SUBJECT: 2486 84th Ave SE
Mercer Island, Washington
RE: Plan Review Comments
Griffith Residence Deck Expansion

The following are our responses to The City of Mercer Island's plan review comments for the above referenced project.

S4.1

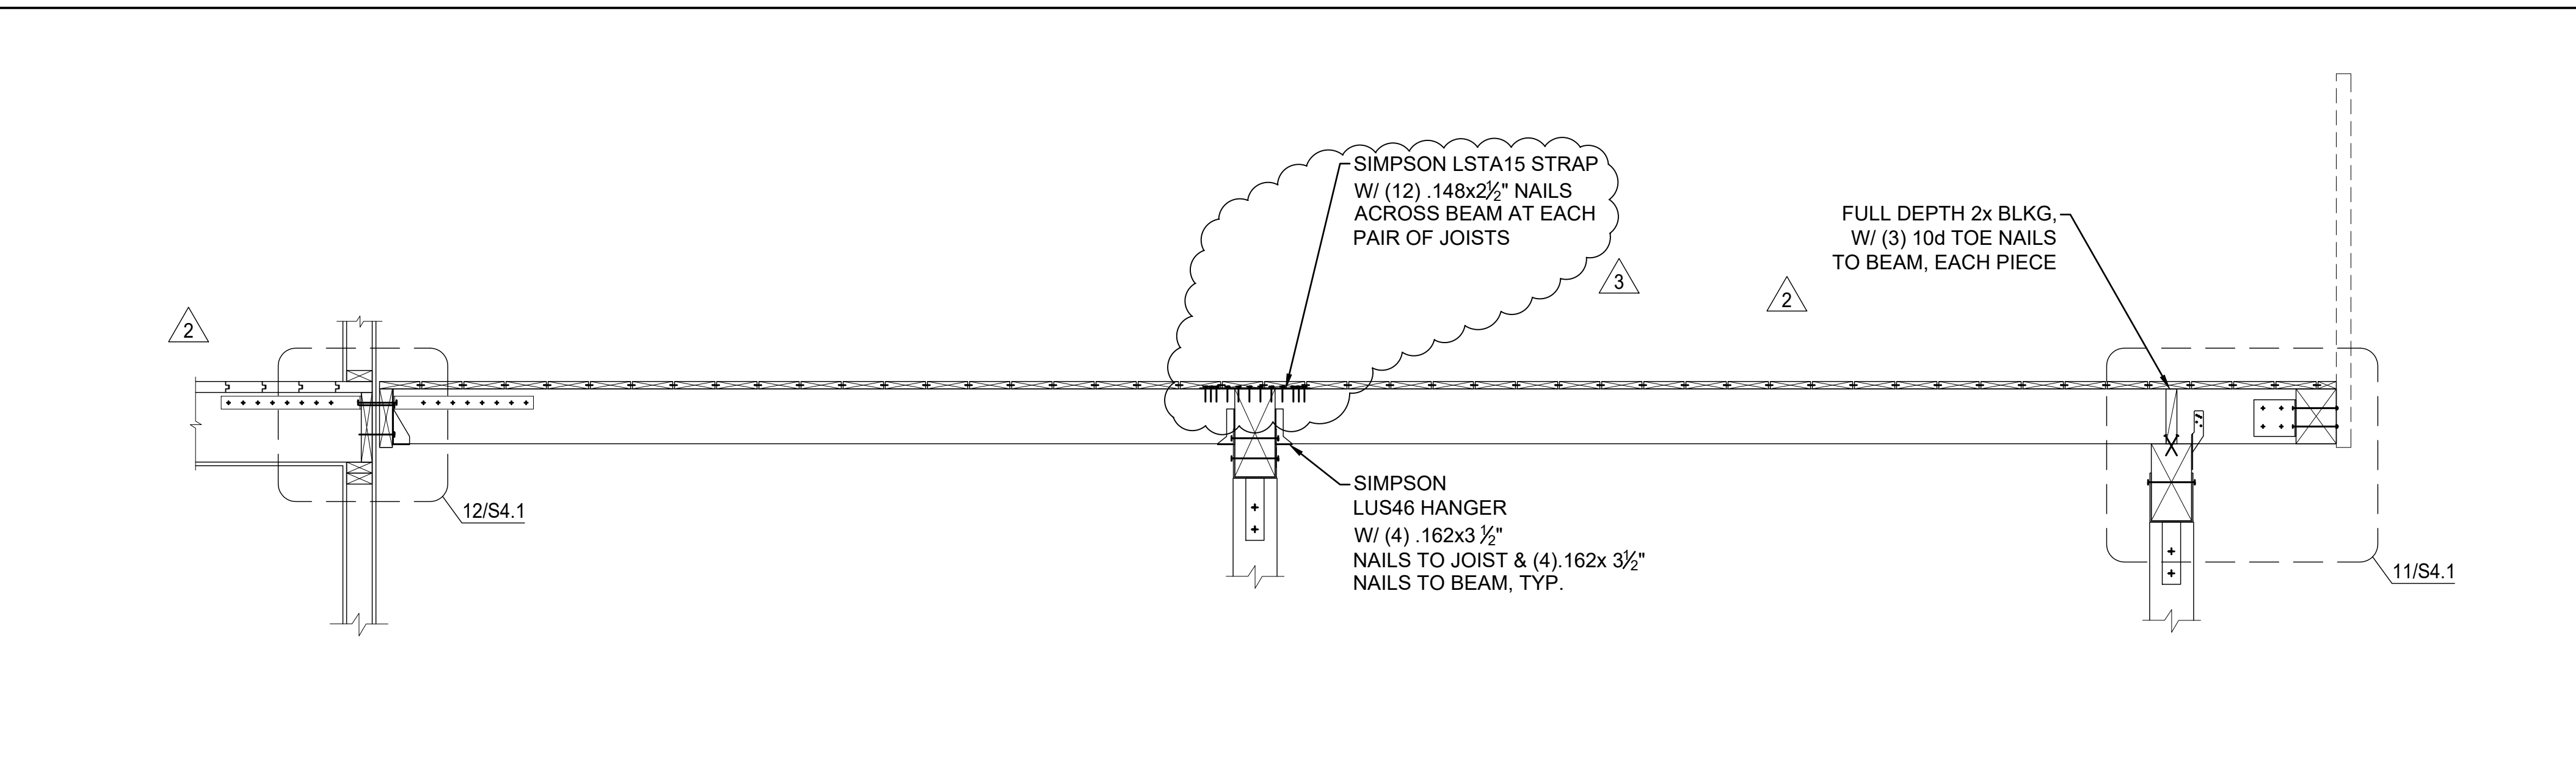
1. Plate size and bolt locations have been added to detail.
2. Please see lateral calculations starting on page 57. The table of contents of the calculations has been updated to note this, instead of "Foundations" twice. Please note that the page numbers in this correction letter (and the table of contents) correspond to the hand written page number in the upper righthand corner, not the page number as identified by Adobe, which counts the cover sheet and table of contents. North-south seismic forces are transferred to the existing house structure at the ledger on the east side of the deck, at the GLB just east of grid 5 at the center, and by the GLB just east of the west edge of the deck. Please note the strap on the GLB in detail 2/S4.1, and the Simpson PBS66 in detail 6/S4.2 which is supporting the beam and has a lateral load capacity of 1,165 lbs. East west seismic forces are transferred to the existing house structure by straps at each joist, see details 8/S4.1 and 9/S4.1 and tie added to detail 1/S4.1 to carry seismic forces across the GLB near grid 5.

3. This is an extraneous note. The note has been removed.
4. Full depth blocking is already provided everywhere, except at the existing garage, where the blocking is moved slightly away from the bearing, and is less than full depth to allow for drainage. Please see detail 8/S4.1. The blocking is nearly full depth, and close enough to the bearing point that it will be adequate.

5. Please see response to comment 2 regarding page numbers. If "eccentric moment" refers to the railing post not necessarily aligning with the joists, note the beam is connected to the joists with the Simpson angle, and will support the moment. Please see page 49 of the calculations.

6. The detail called out is incorrect. The note has been revised to read 10/S4.1.
7. Please see revised detail 3/S4.1.
